# KITTITAS COUNTY

## DEPARTMENT OF PUBLIC WORKS

**TO:** All Staff  
**FROM:** Public Works Plan Review Team  
**DATE:** December 28, 2023  
**SUBJECT:** BL-23-00026 MTA Ranch

SHEET 1 OF 2

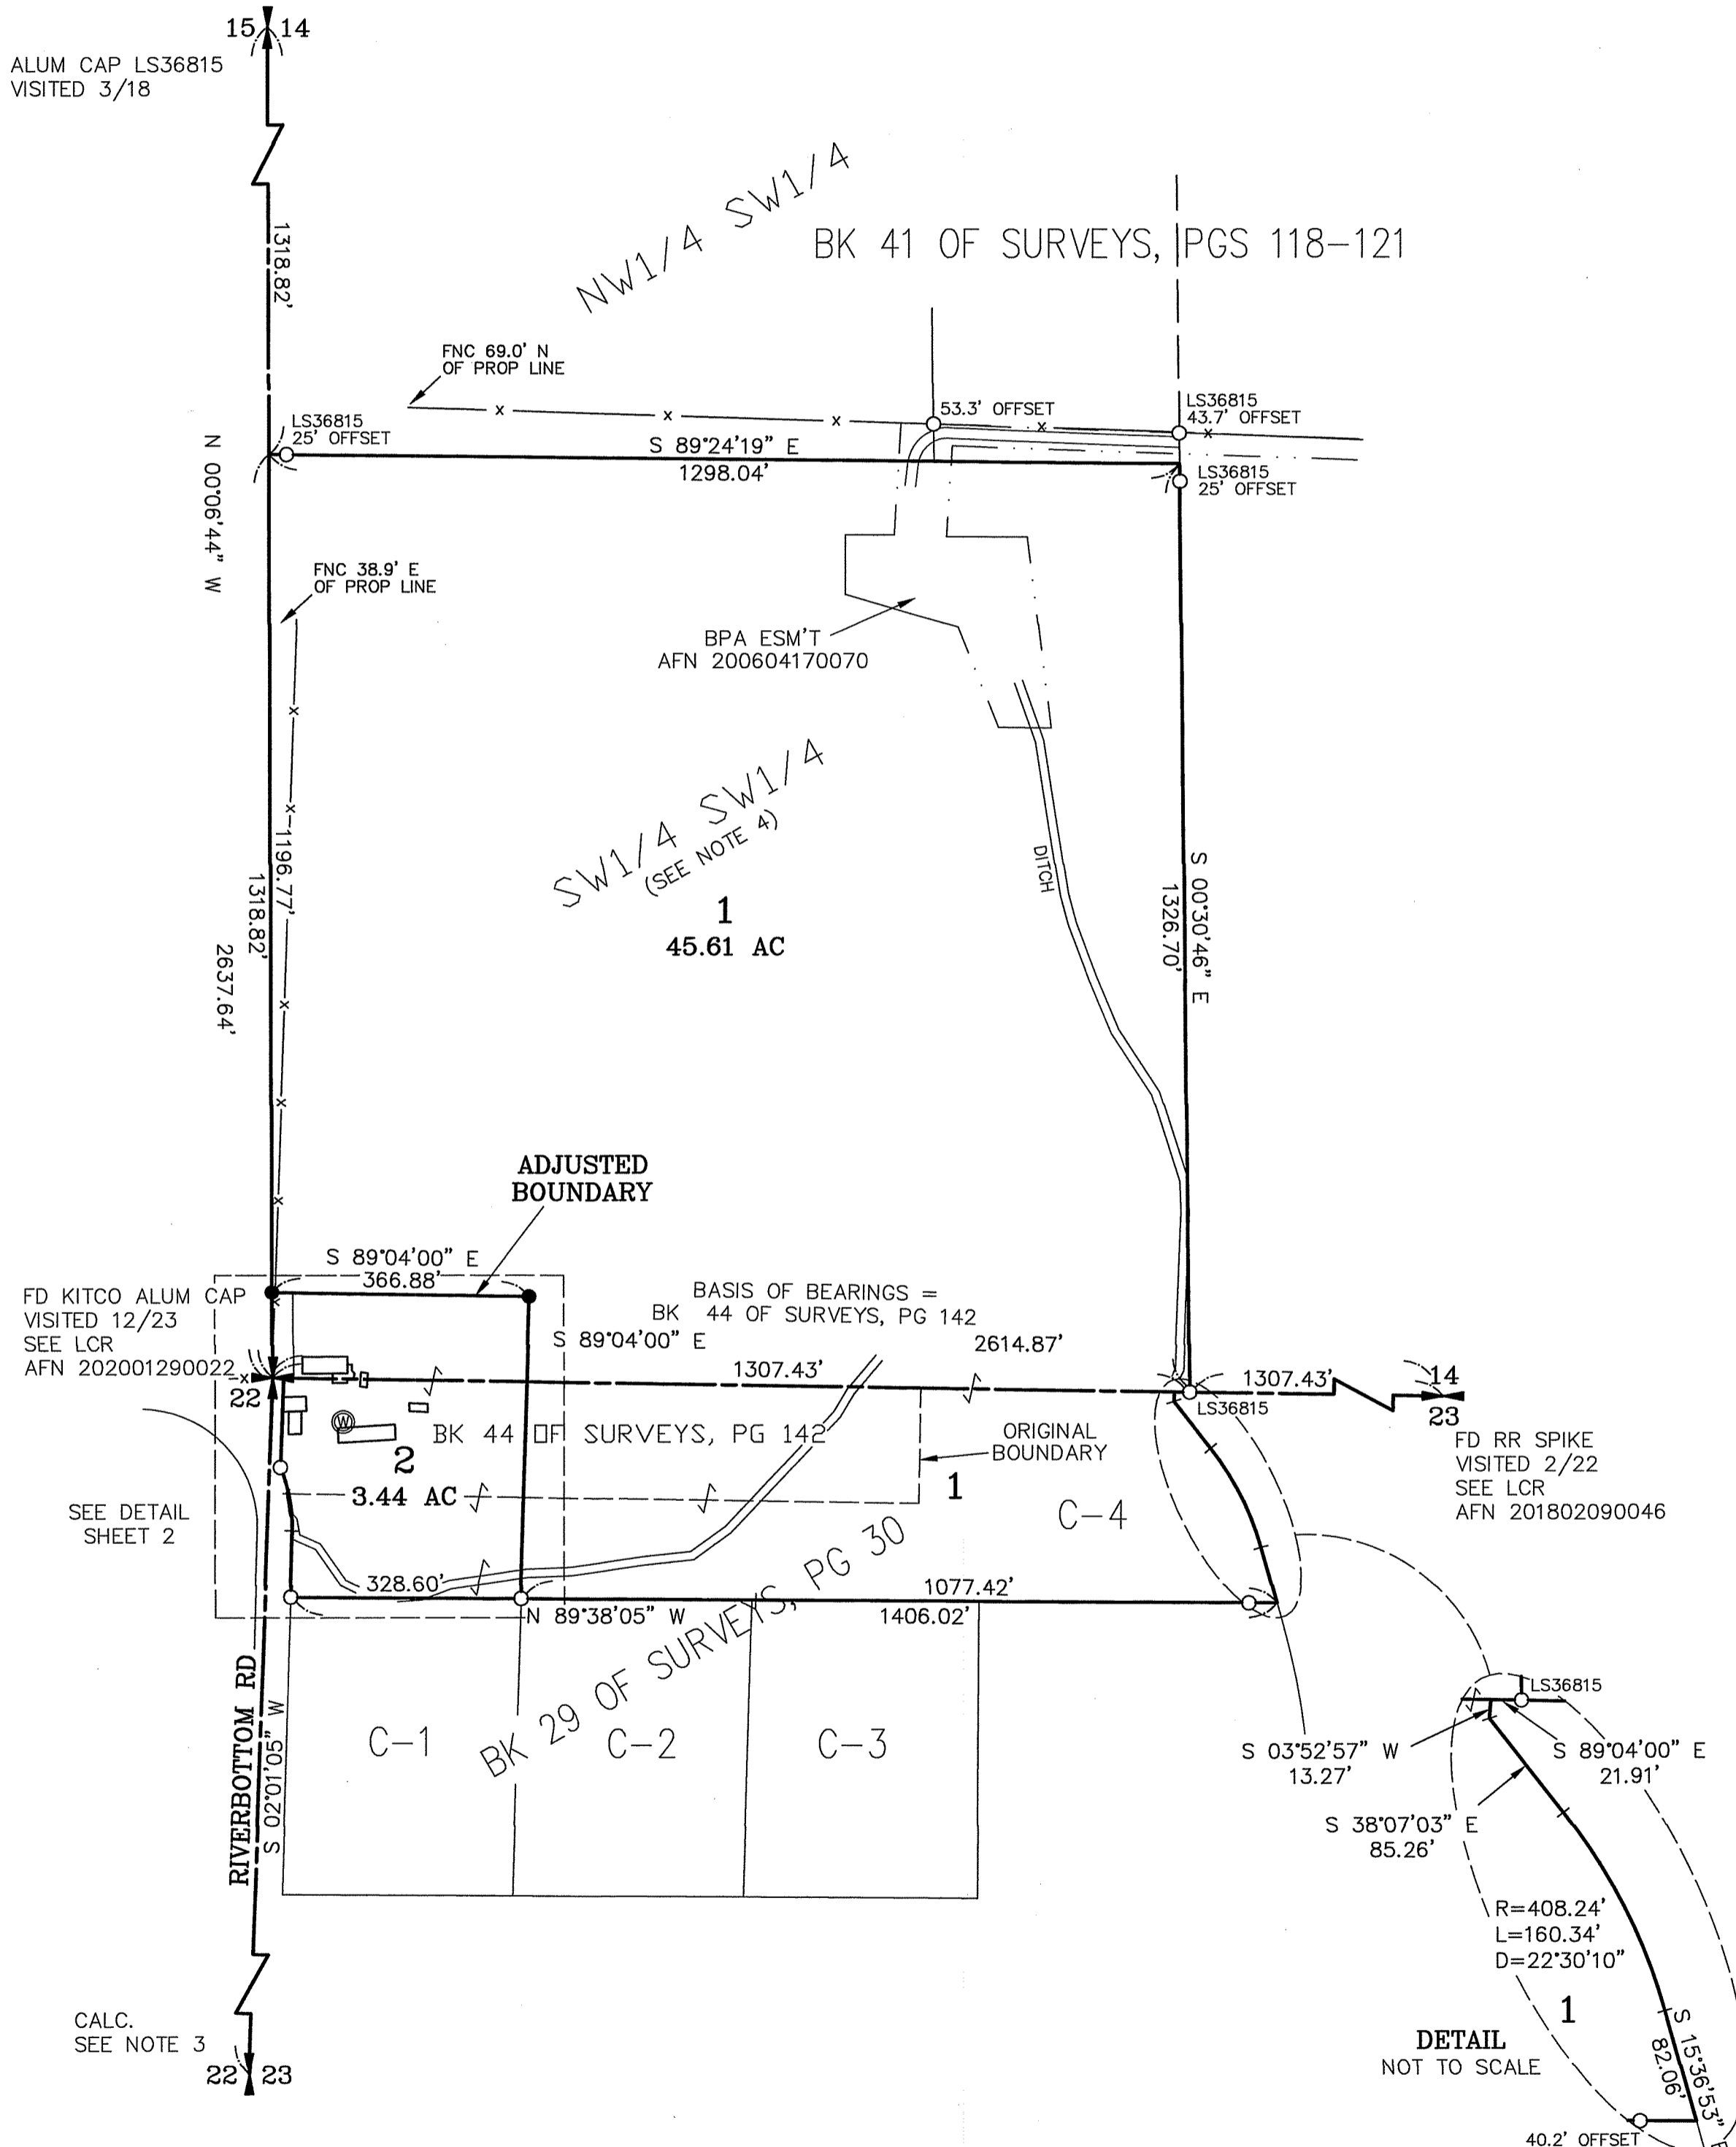
<b>ENGINEERING</b>	No Comments (CC)
<b>SURVEY</b>	<p>As the application does not contain a survey map, comments are reserved until final. (JT)</p> <p>UPDATE 12/27/2023          There are no survey changes required to this application.</p> <p>Of Note          There MAY be usage lines or encroachments that should be shown, based upon aerial images, particularly along the fence deviation near the canal on the south edge of the development, and the usage of the irrigation pivot over the fields of both Siltman and MTA. (JT)</p>

**EASEMENT M**

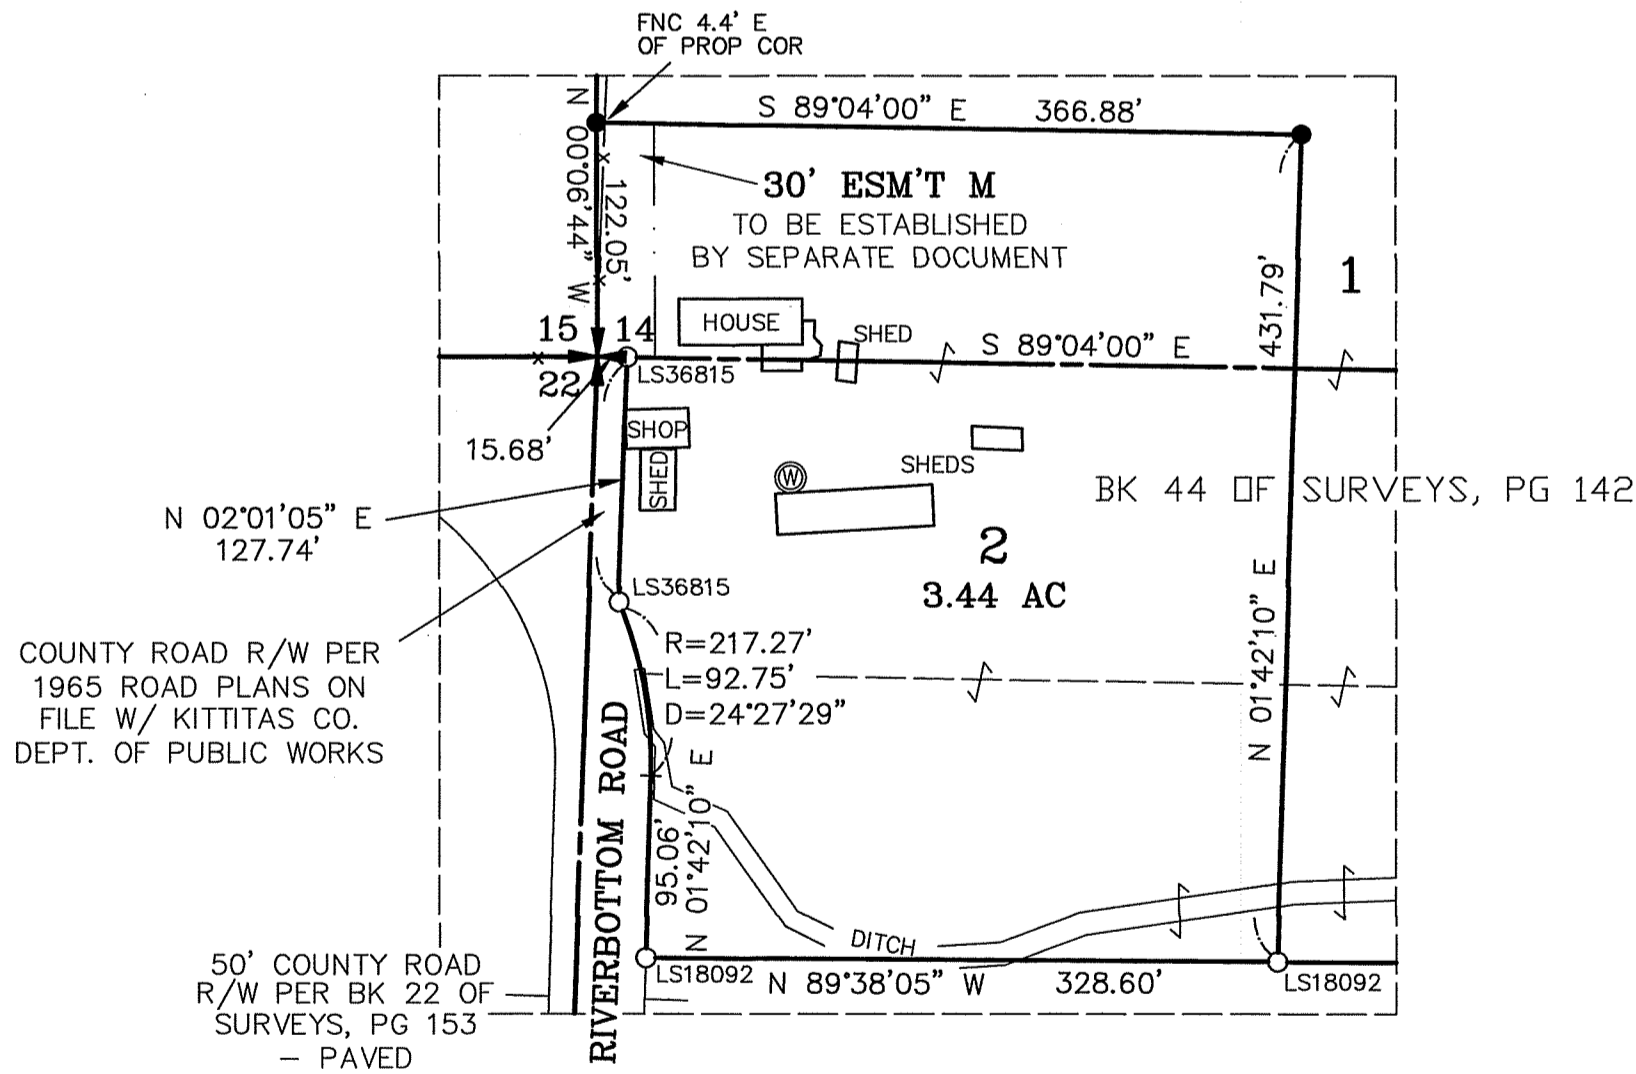
<b>ACCESS</b>	<ol style="list-style-type: none"> <li>1. Update 10/27/23-30 foot easement is required and shall extend to Riverbottom Road right of way. Must include 30 feet of Riverbottom Road frontage.</li> <li>2. An approved access permit shall be required from the Kittitas County Department of Public Works prior to creating any new driveway access or altering an existing access.</li> <li>3. Maintenance of driveway approaches shall be the responsibility of the owner whose property they serve. The County will not maintain accesses.</li> <li>4. Any further subdivision or lots to be served by proposed access may result in further access requirements. See Kittitas County Road Standards.</li> <li>5. In addition to the above-mentioned conditions, all applicable Kittitas County Road Standards apply to this proposal. Access is not guaranteed to any existing or created parcel on this application.</li> </ol>
